24 September 2018

File No: 2018/487955  
Our Ref: R/2018/12/A  
Your Ref: SSD 9347

**RE: Amending Stage 1 Concept Proposal (south site building envelope)  
Sydney Metro Martin Place (SSD 9347)**

Stage 2 South Tower footprint

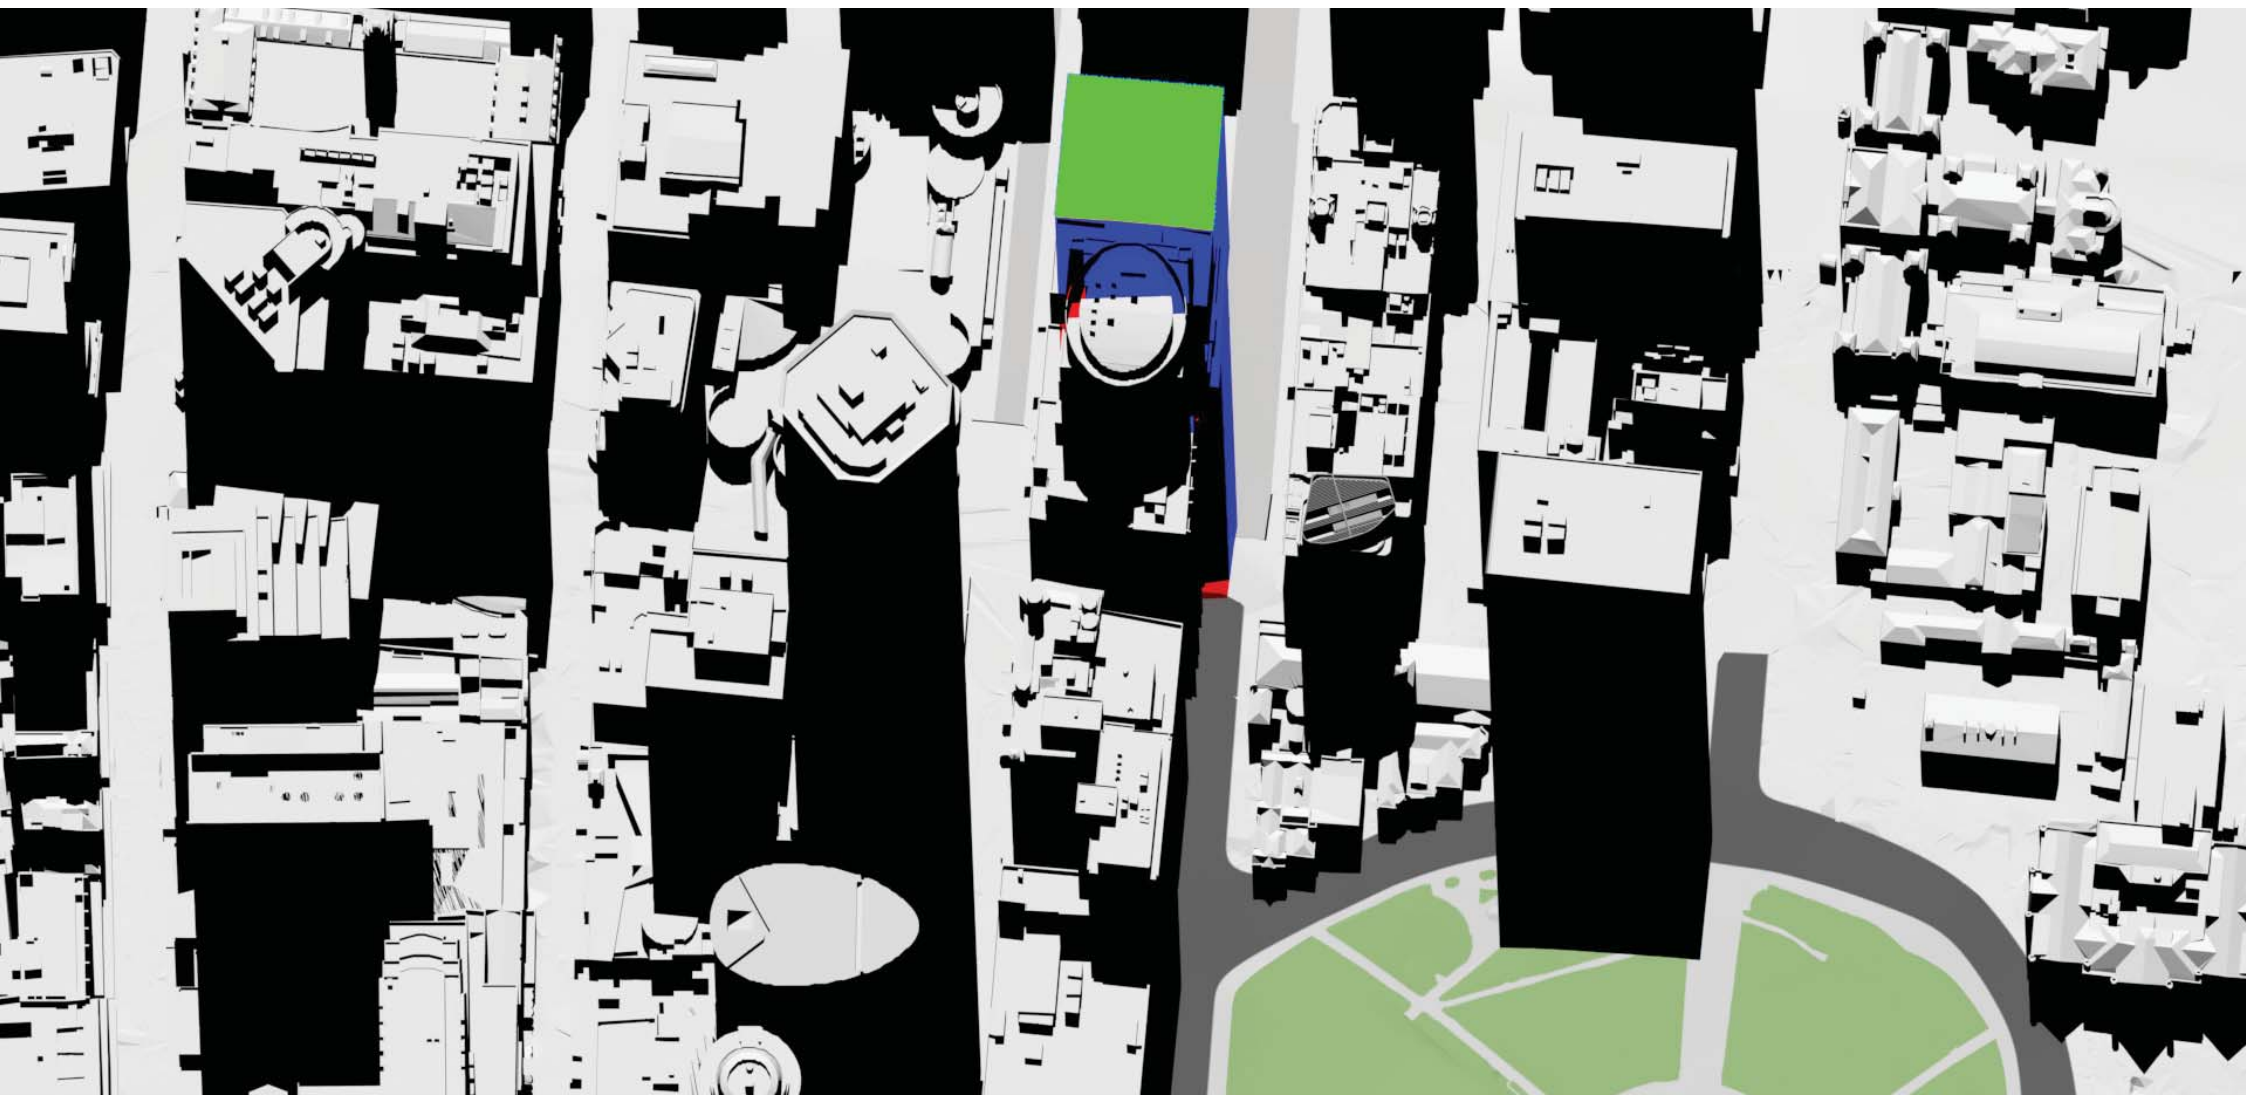
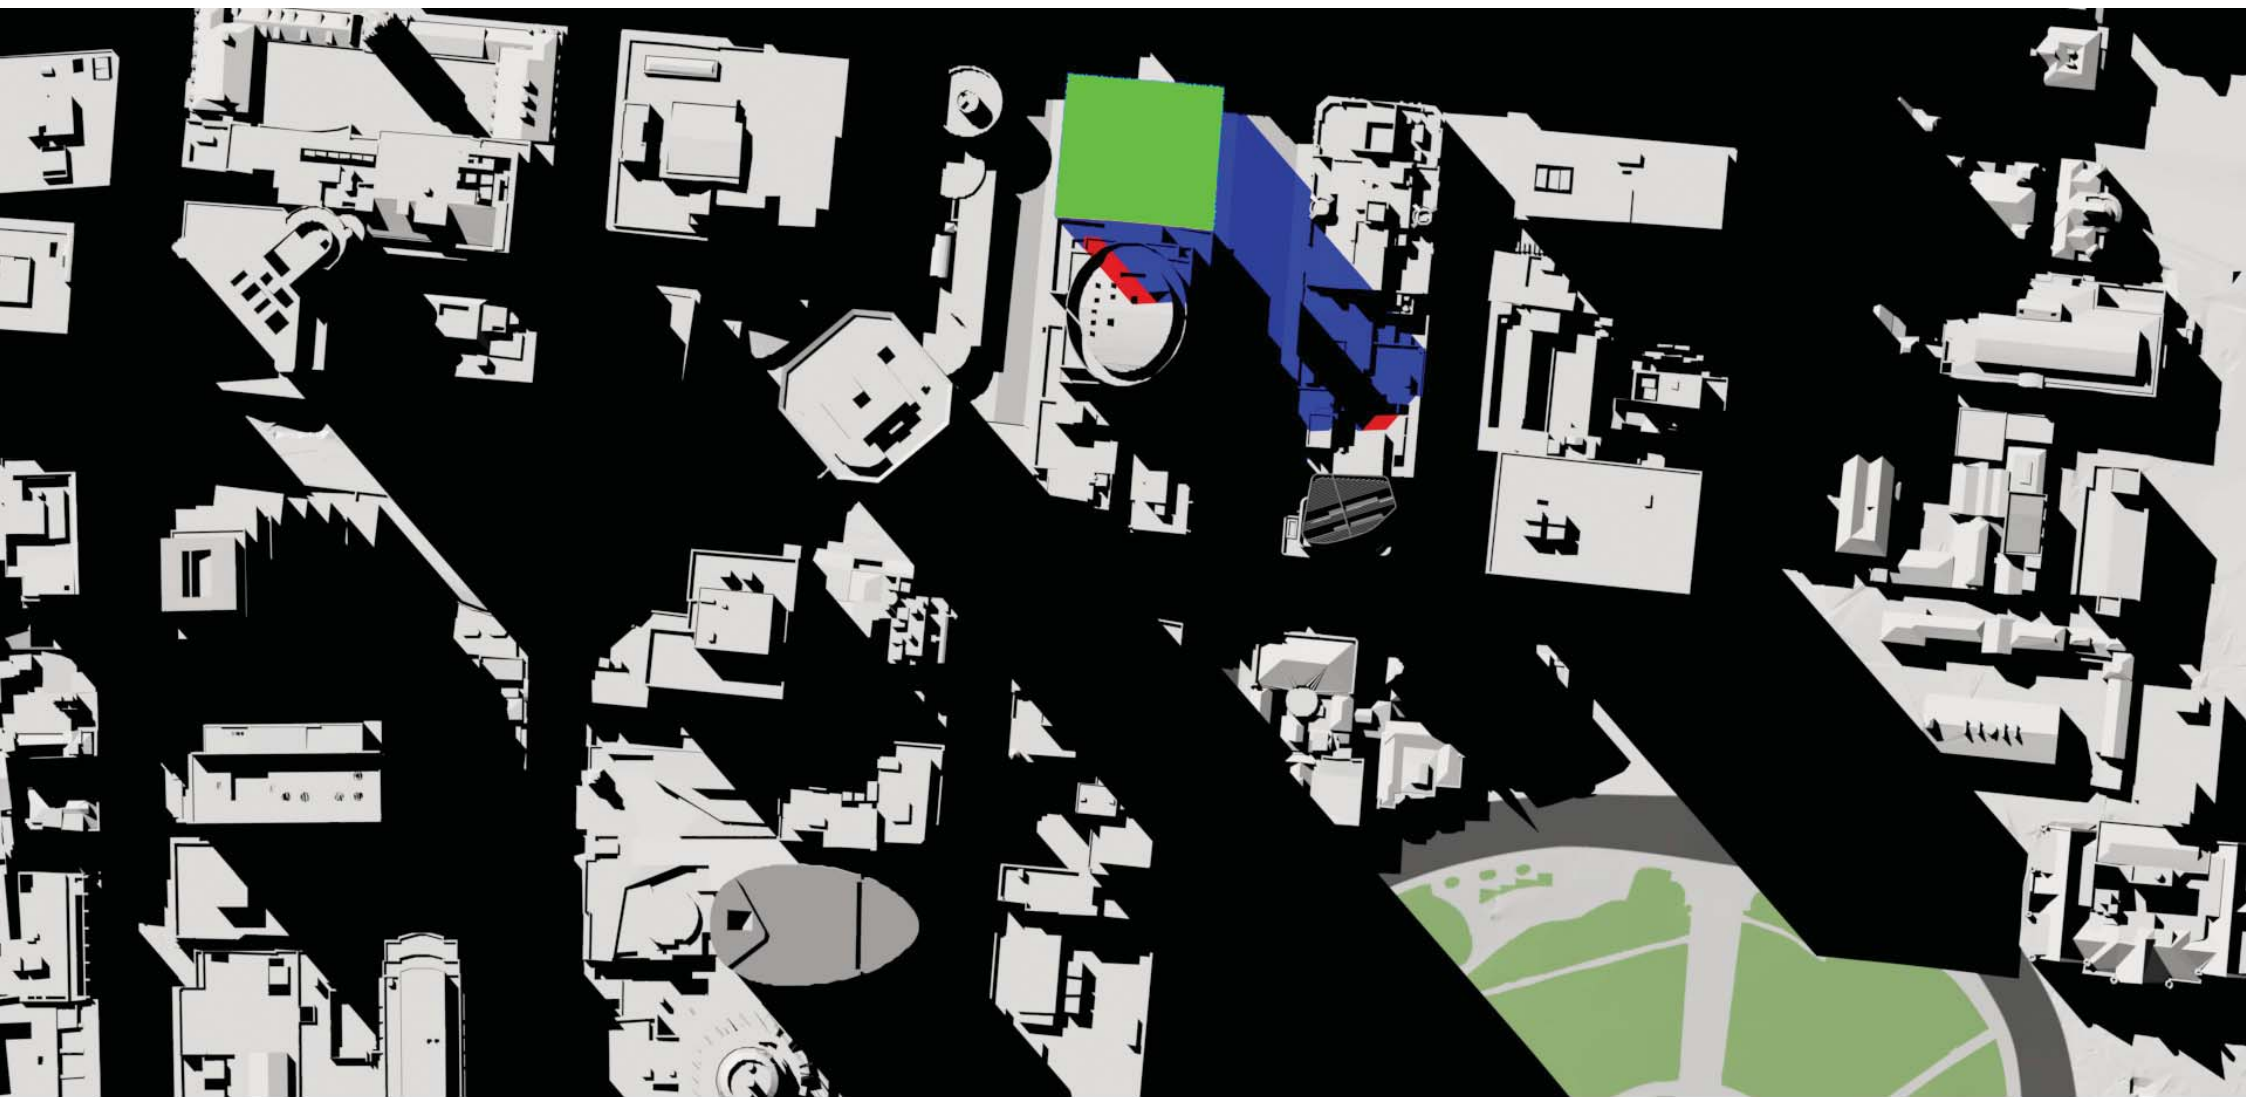
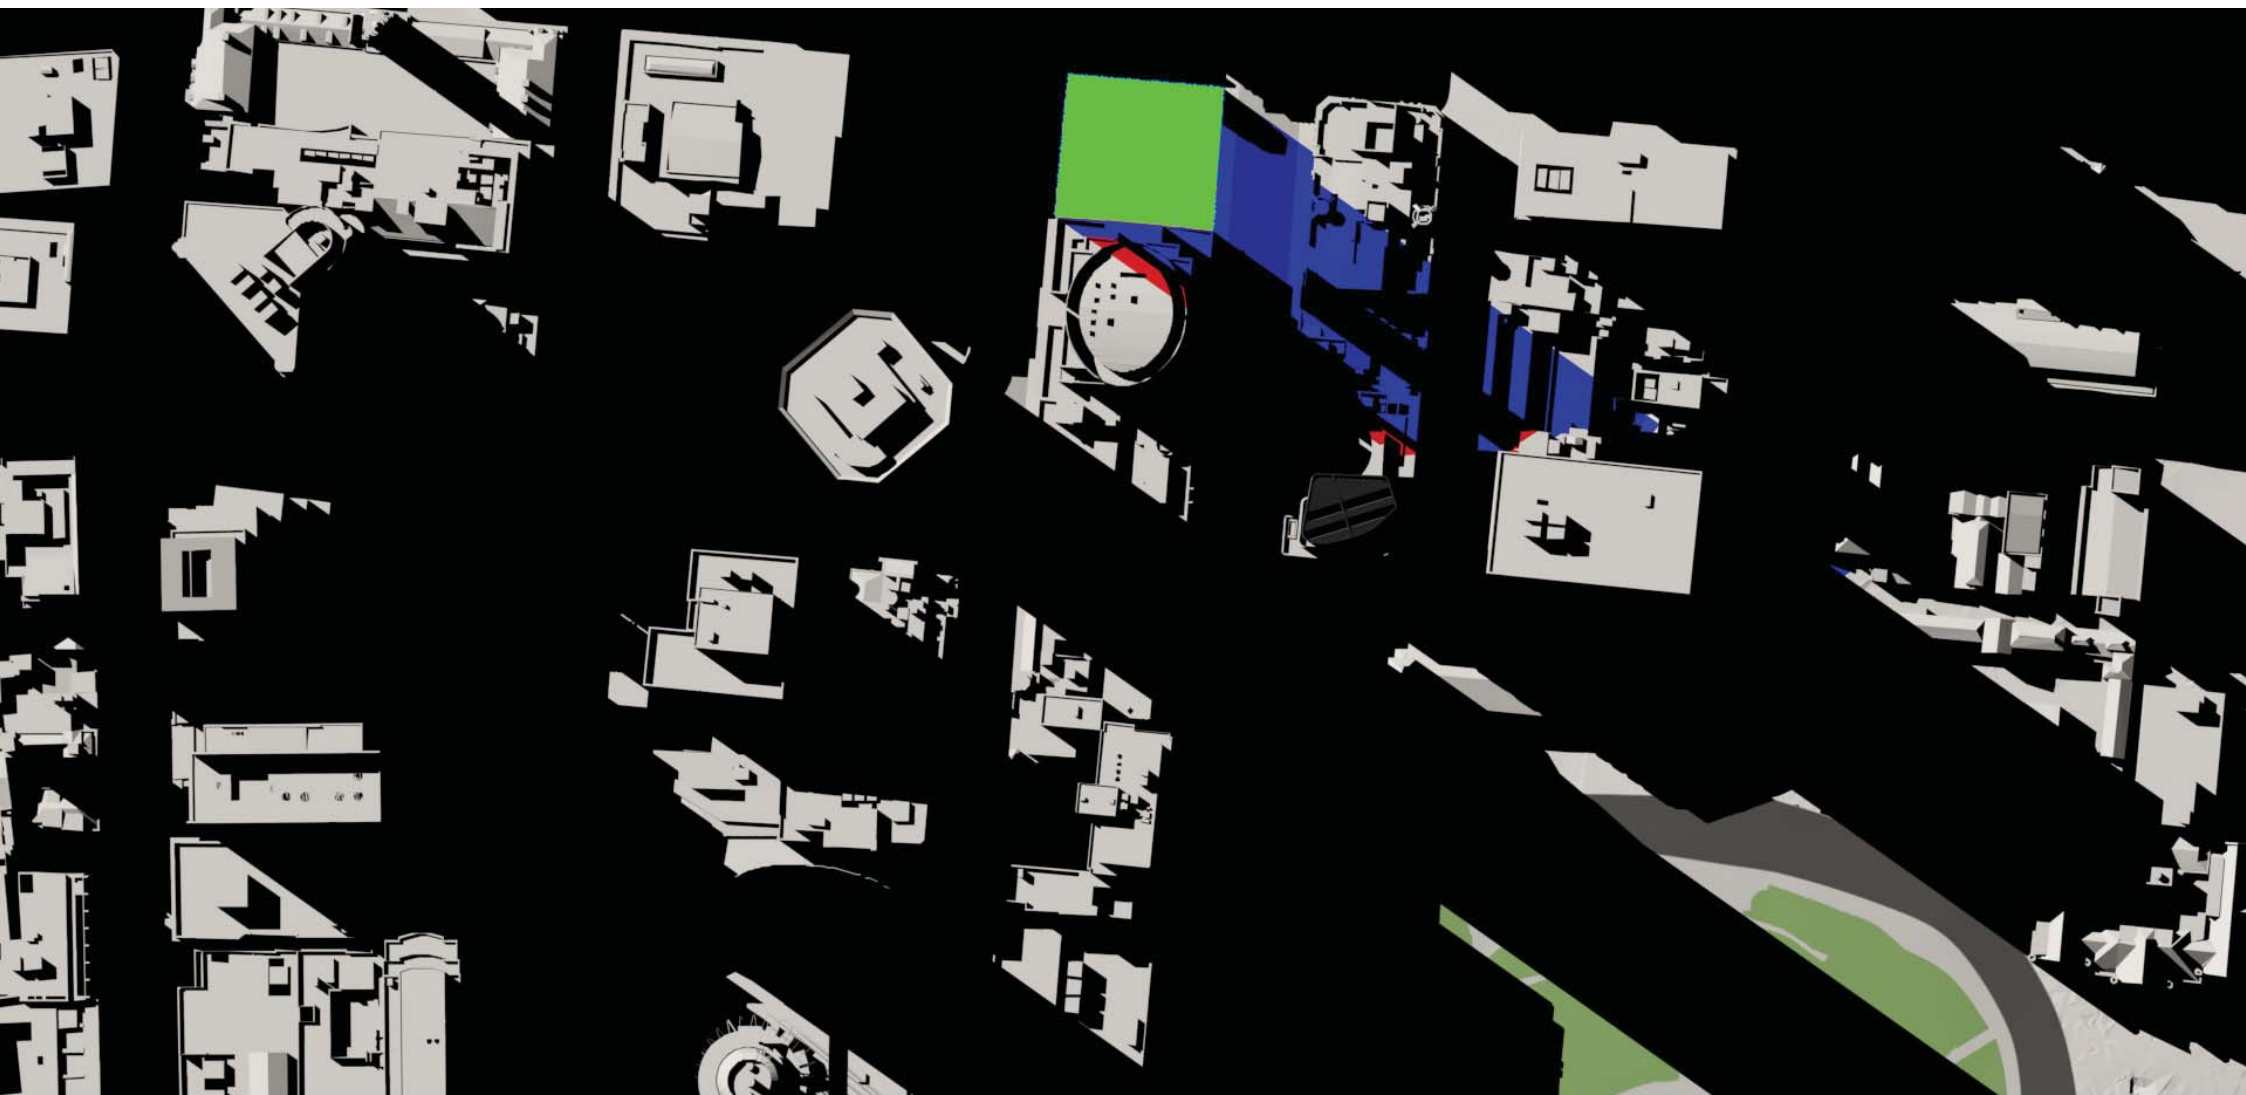
In lieu of incorporating the Planning Assessment Commission's (PACs) recommendations regarding street frontage conditions along Elizabeth and Castlereagh Streets as part of the existing concept approval (SSD 8351), it is recommended that in amending the concept envelope and increasing the building mass of the south tower, building returns be incorporated in the southern corners of the envelope as a transition to the adjoining development to the south above the podium height. This would in part assist in achieving the outcome of the PACs' advice of reinforcing the importance of the urban character and integrity of Martin Place and the associated city blocks. A return of 8m x 8m is recommended for each corner for the tower above a nominal 45m podium height.

An attached diagram from the proposed concept envelope illustrates this recommendation.
